ADDRESS : 655 FLINTLOCK LN
 CONTRACTOR : J & W CUSTOM BUILDERS INC
 OWNER : NC CORRAL LLC
 PARCEL : 05-0624- - -0040- -03-
 APPL NUMBER: 16-50039383 CP NEW RESIDENTIAL (SFD)
 DIRECTIONS : US401NW/ L@ CHRISTIAN LIGHT/ L@ RIVER/
 L@ FLINTLOCK LN/ LOT IS ACROSS STREET
 FROM 634

STRUCTURE: 000 000 2800 SQFT 2BDR W/REC ROOM W/DECK CRAWL

PERMIT: CPSF 00 CP * SFD

1 12" CMU GARAGE FOUNDATION WALL

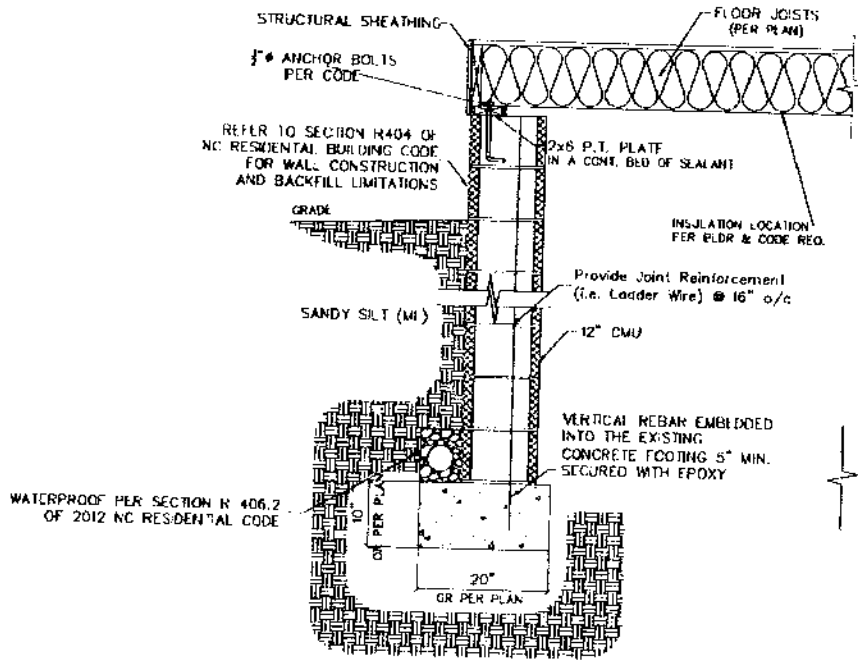
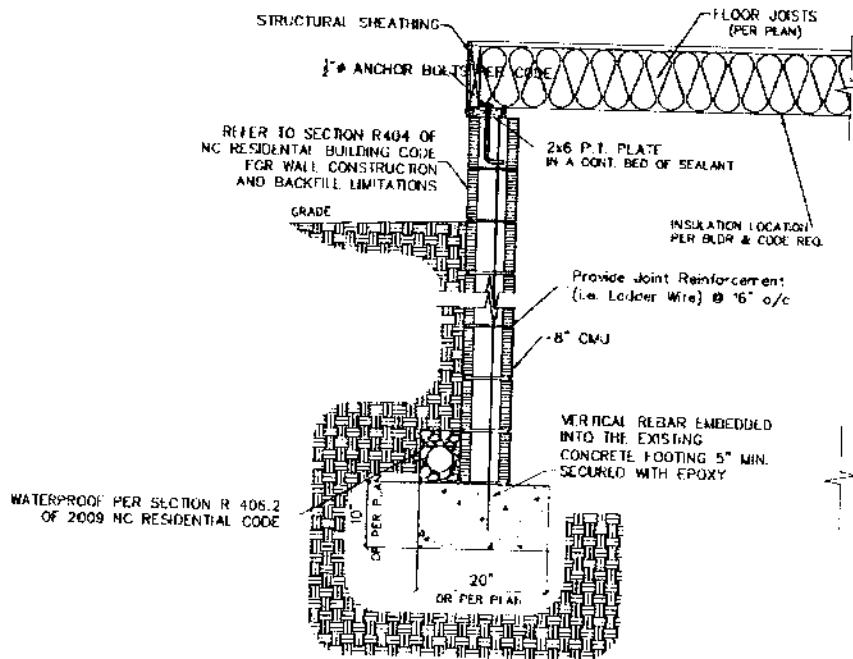
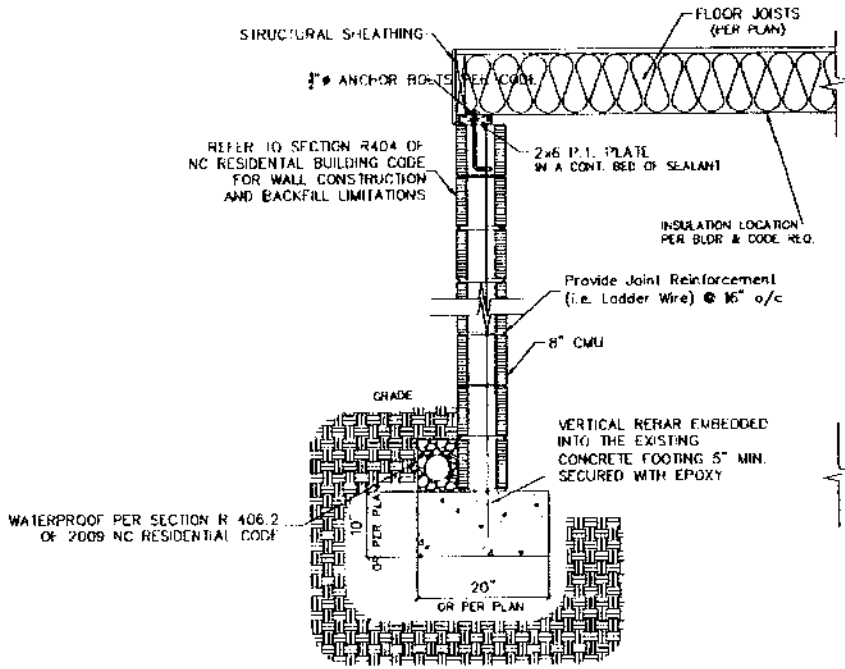
TYP/SQ	REQUESTED COMPLETED	INSP RESULT	DESCRIPTION RESULTS/COMMENTS
B101 01	9/19/16 9/19/16	BS DA	R*BLDG FOOTING / TEMP SVC POLE TIME: 17:00 VRU #: 002872752 T/S: 09/16/2016 09:13 AM JFORBES T/S: September 19, 2016 10:02 AM BSUTTON Engineered plan calls for #4 vertical rebar in all walls above 4 feet high, and all piers in each cell. This must b in place at time of footing inspection. Call to reschedule.
B101 02	9/23/16 9/23/16	BS AP	R*BLDG FOOTING / TEMP SVC POLE TIME: 17:00 VRU #: 002875524 T/S: 09/22/2016 12:13 PM LBENNETT T/S: 11/15/2016 09:33 AM DJOHNSON
A814 01	12/01/16 12/01/16	SB AP	ADDRESS CONFIRMATION TIME: 17:00 VRU #: 002904878 655 FLINTLOCK LN FUQUAY VARINA 27526 POST ADDRESS AT LONG DRIVE WAY T/S: 12/01/2016 09:31 AM SBENNETT
B103 01	12/02/16 12/02/16	BS AP	R*BLDG FOUND & TEMP SVC POLE TIME: 17:00 VRU #: 002905784 T/S: 12/01/2016 01:40 PM JFORBES T/S: December 02, 2016 09:17 AM BSUTTON Engineering attached

Roof Framing

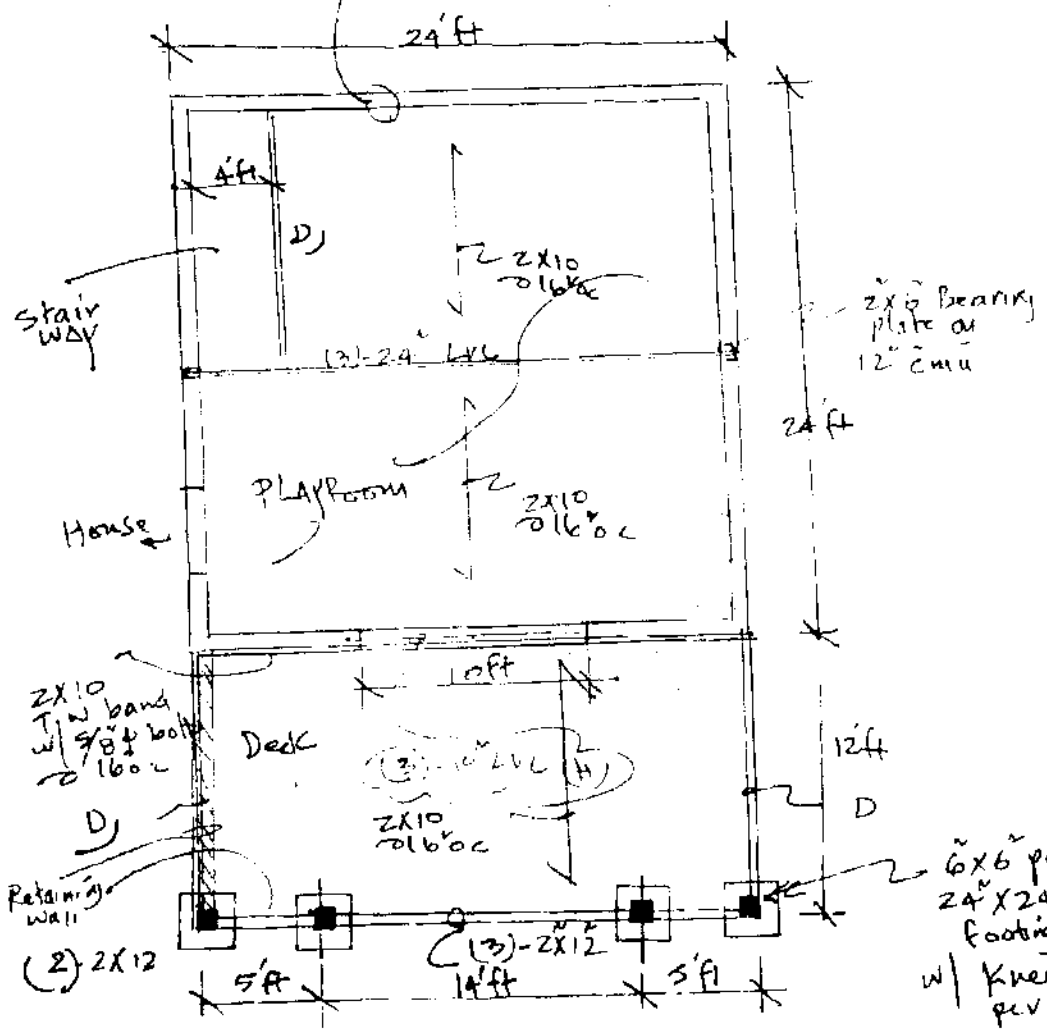
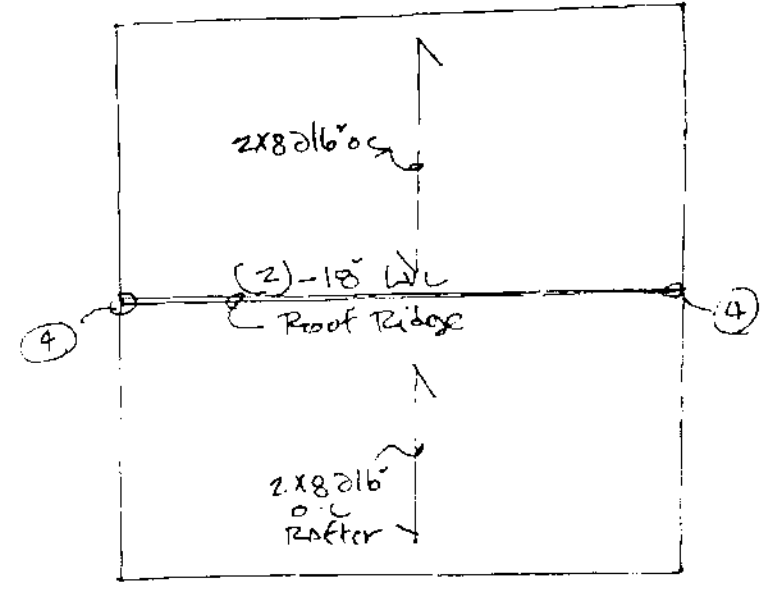
TYP/SQ	REQUESTED COMPLETED	INSP RESULT	DESCRIPTION RESULTS/COMMENTS
			Need attic access over main portions of house. Small garage does not require attic access (less than 400 Sqft)2. Need engineering on master roof redesign. 3. Strap washing machine vent. 4. INstall fireplace for inspection. Do not cover chimney before inspection (factory built wood burner) Ok to insulate
E207 02	2/16/17	BS	R*ELEC TEMP SERVICE POLE TIME: 17:00 VRU #: 002934149
	2/16/17	AP	T/S: 02/15/2017 03:21 PM LBENNETT ----- T/S: February 16, 2017 07:56 AM BSUTTON -----
I129 01	2/20/17	BS	R*INSULATION INSPECTION TIME: 17:00 VRU #: 002934883
	2/20/17	AP	T/S: 02/17/2017 10:41 AM DJOHNSON ----- T/S: February 20, 2017 09:38 AM BSUTTON -----
R425 02	2/20/17	BS	FOUR TRADE ROUGH IN TIME: 17:00 VRU #: 002934875
	2/20/17	AP	T/S: 02/17/2017 10:41 AM DJOHNSON ----- T/S: February 20, 2017 09:38 AM BSUTTON ----- Still need chases framed and firestopped, attic access framed, and fireplace install. T/S: March 09, 2017 10:20 AM BSUTTON ----- Changed to AP. All corrections were made except fireplce. It will be installed in two weeks
